Filing No. 1

Updated Traffic Impact Analysis

PCD File No. SF-18-00

April 5, 2018

FLYING HORSE NORTH FILING NO. 1 STREET IMPROVEMENT PLAN ROUNDABOUT 1 PLAN AND PROFILE PLAN					
DESIGNED BY	PRA	SCALE	DATE 08-11-17		
DRAWN BY	PRA	(H) 1"= 50'	SHEET	26	OF 58
CHECKED BY	(V)	1"= 5'	JOB NO.	1096.11

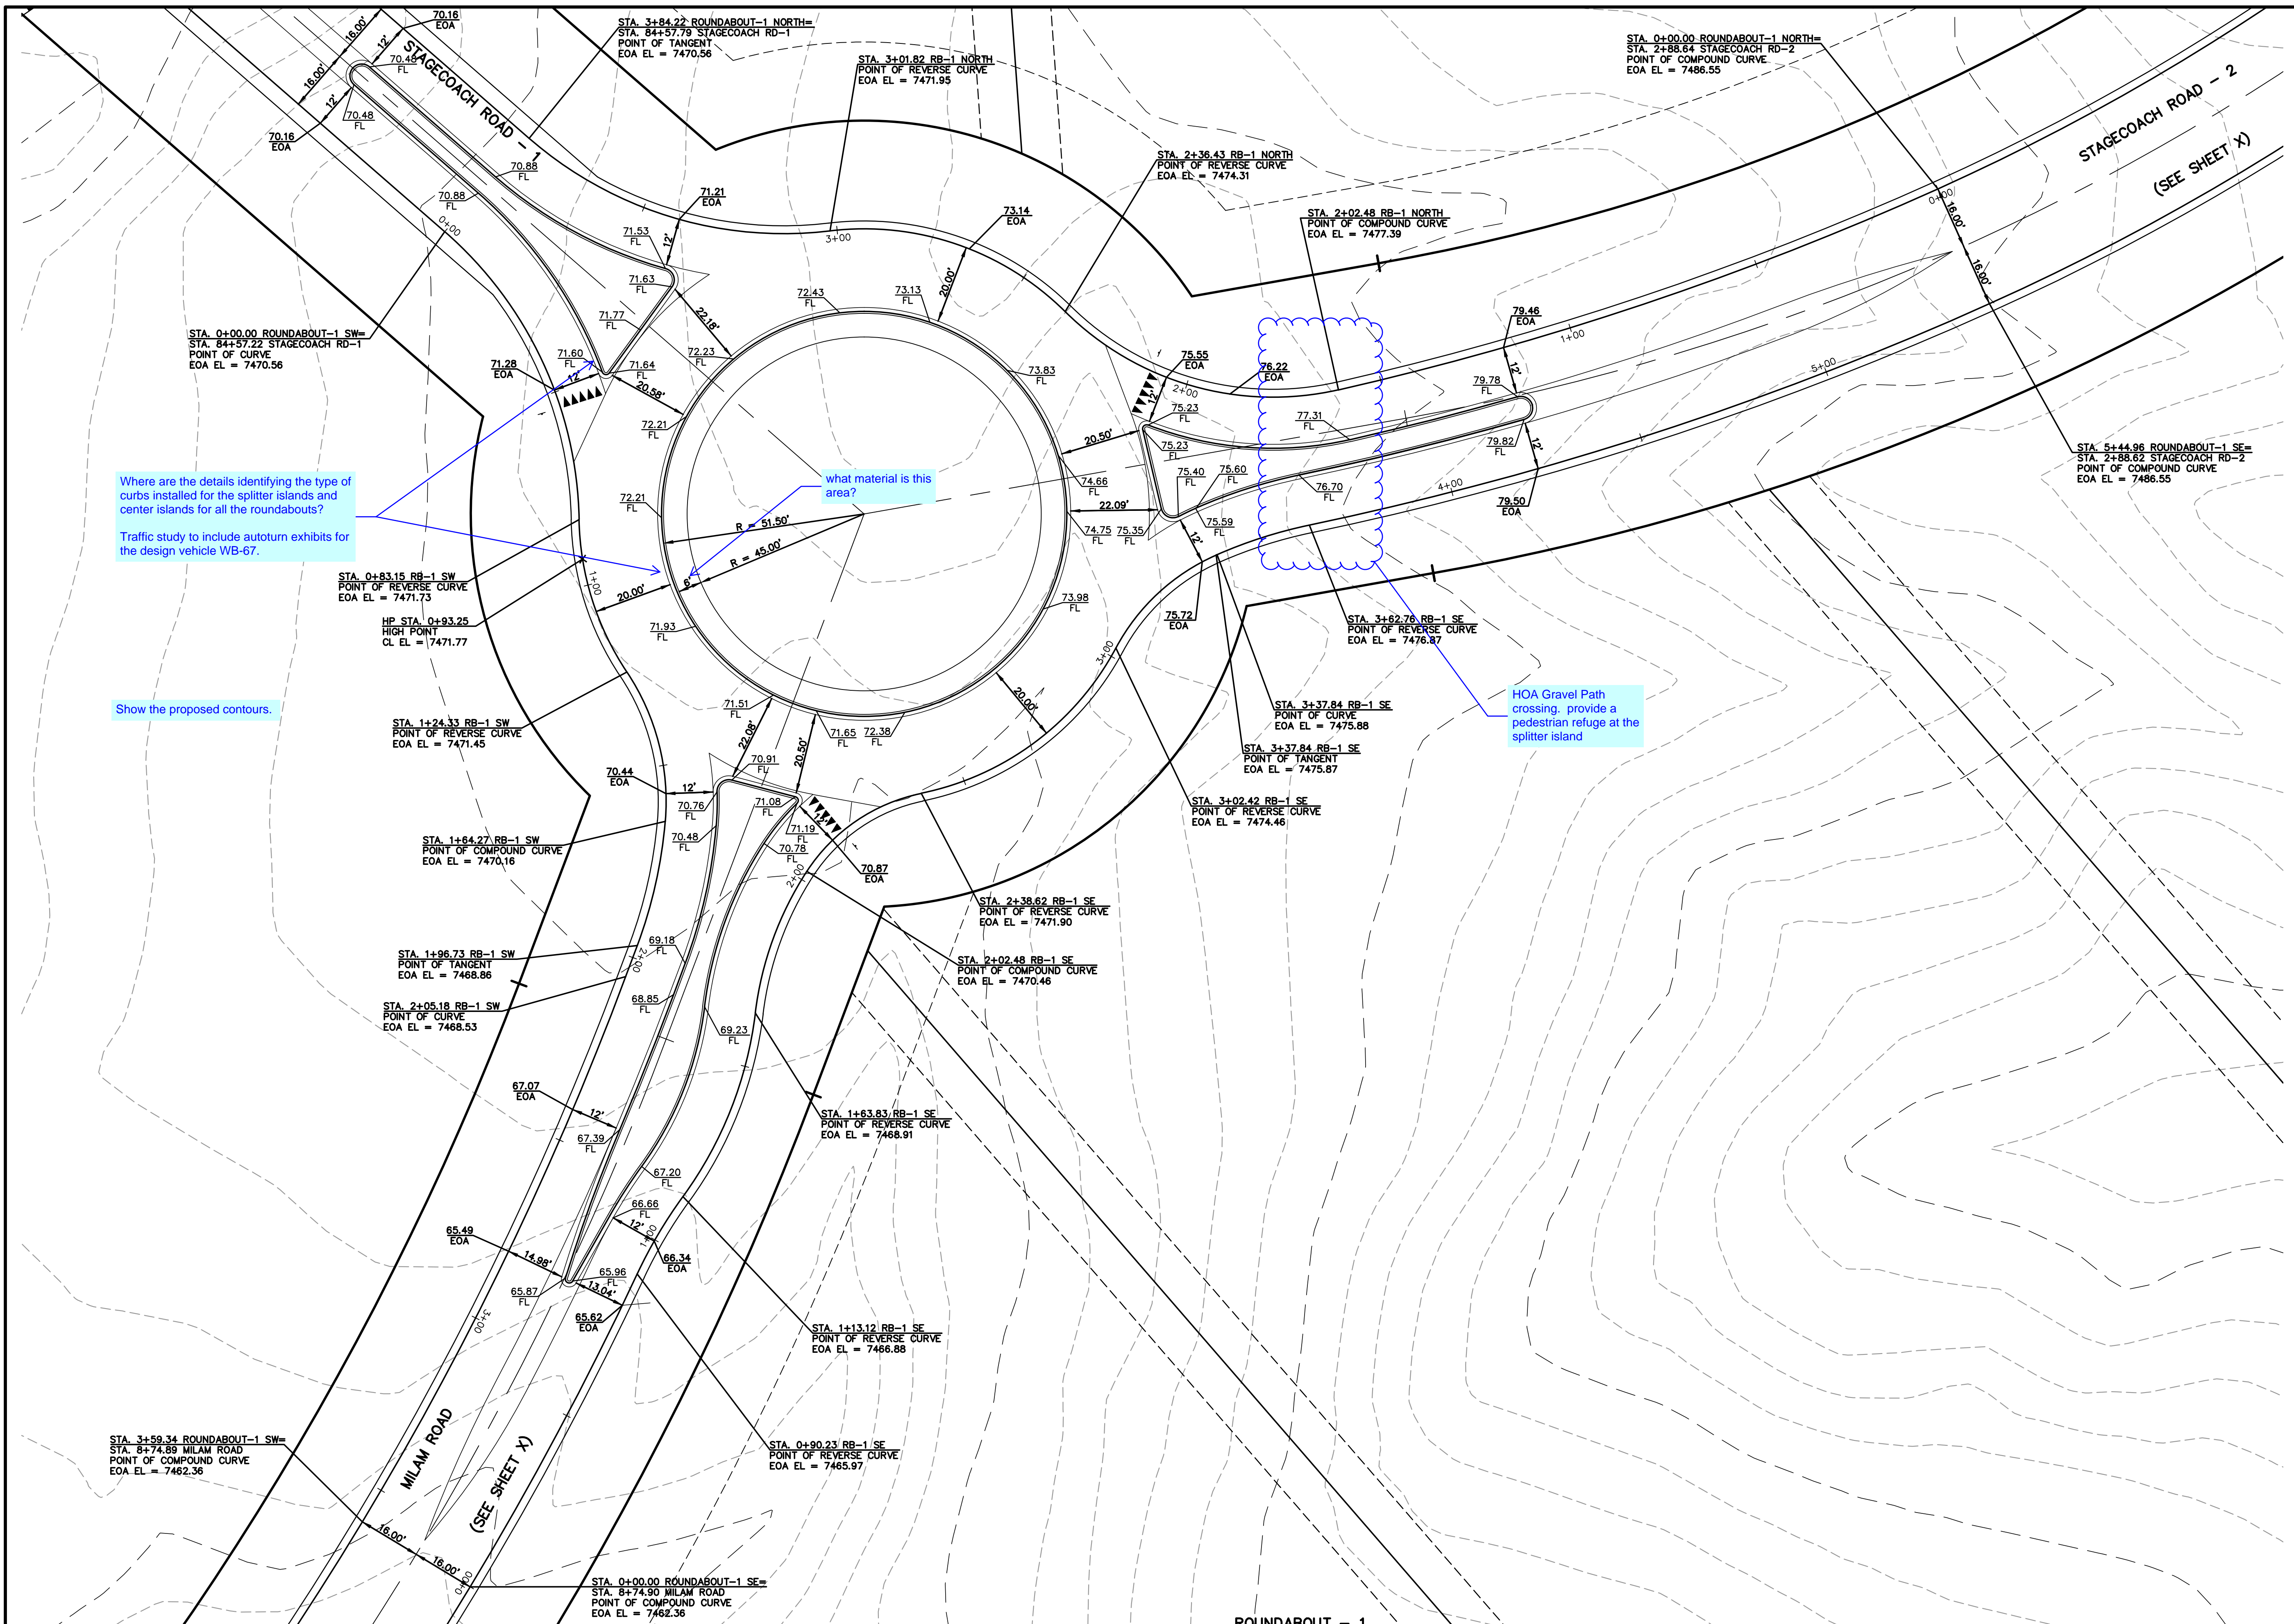
³ Include autoturn exhibits of WB-67 trucks at each roundabout.

⁴ Please refer to the responses to the construction drawing comments. The roundabout design was completed by Classic Consulting. A note to this effect has been added to the update TIS.

N:\09611\DRAWINGS\CONSTRUCTION\109611-SI-37.dwg, 12/15/2017 7:50:41 AM, DWG To PDF.pc3

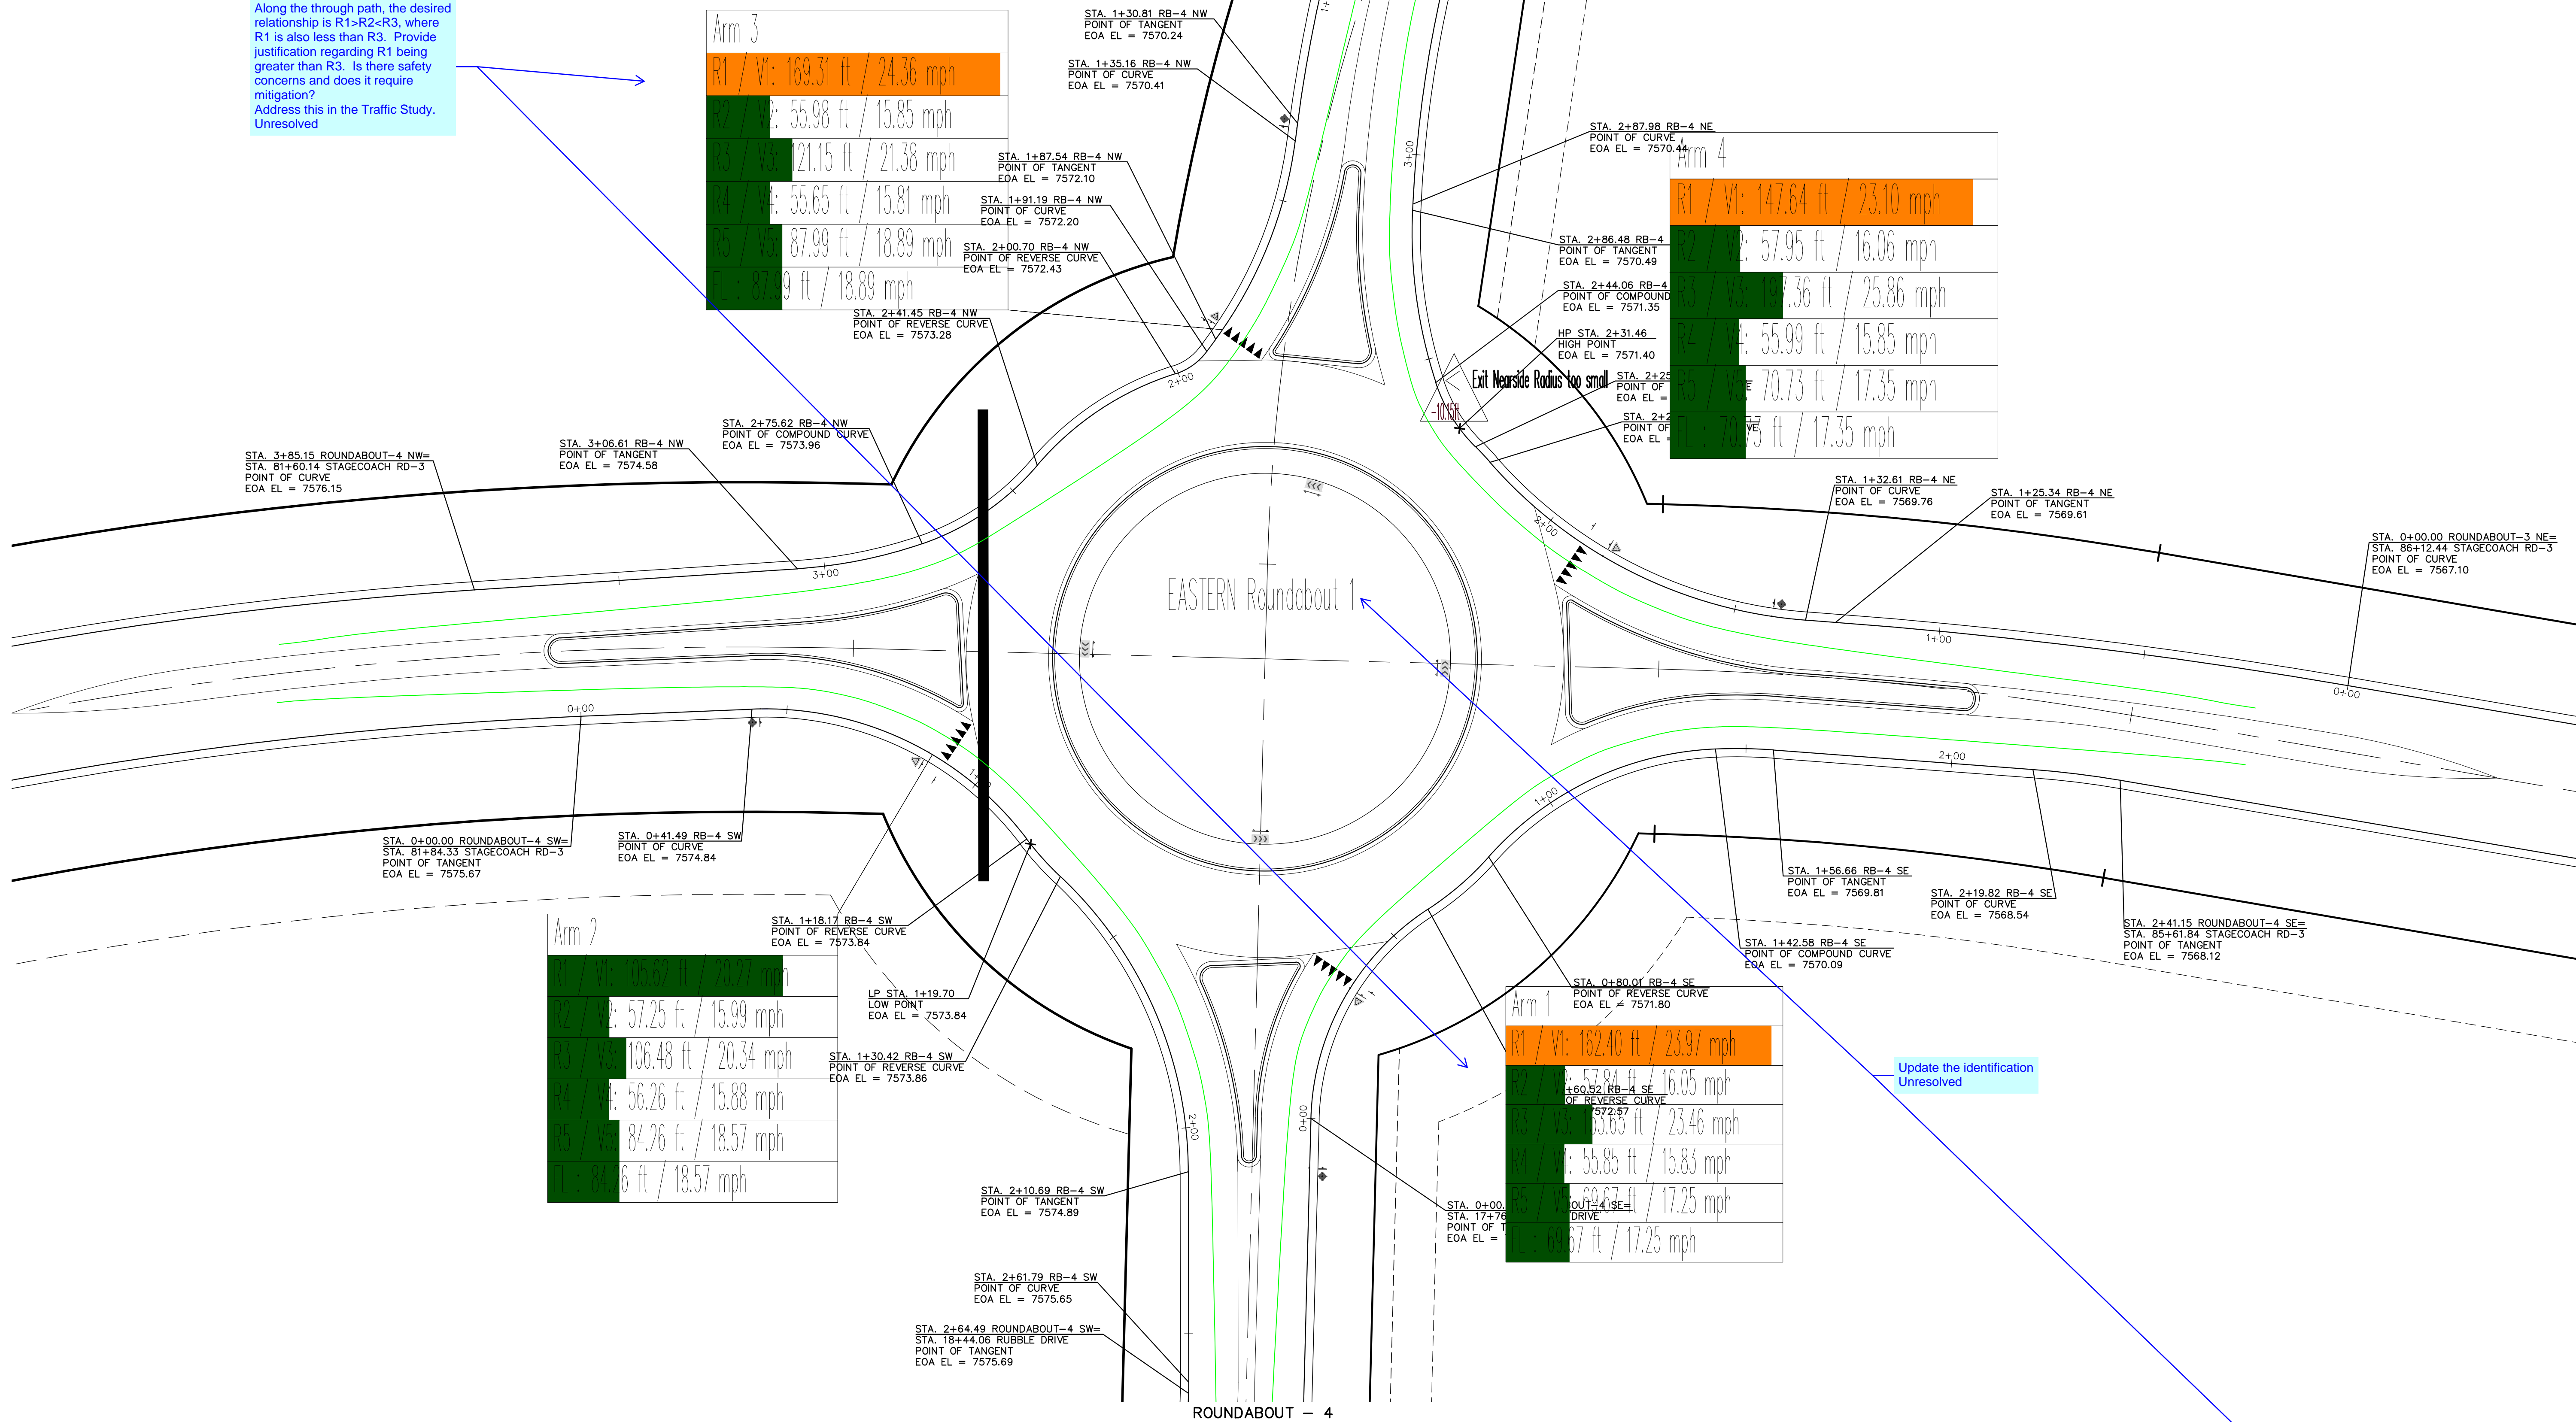
¹ Along the through path, the desired relationship is $R1 > R2 < R3$, where R1 is also less than R3. Provide justification regarding R1 being greater than R3. Is there safety concerns and does it require mitigation?
Address this in the Traffic Study.
Unresolved. This is a comment made in sheet 37 of the construction drawings.

² Please refer to the responses to the construction drawing comments. The roundabout design was completed by Classic Consulting. A note to this effect has been added to the update TIS.
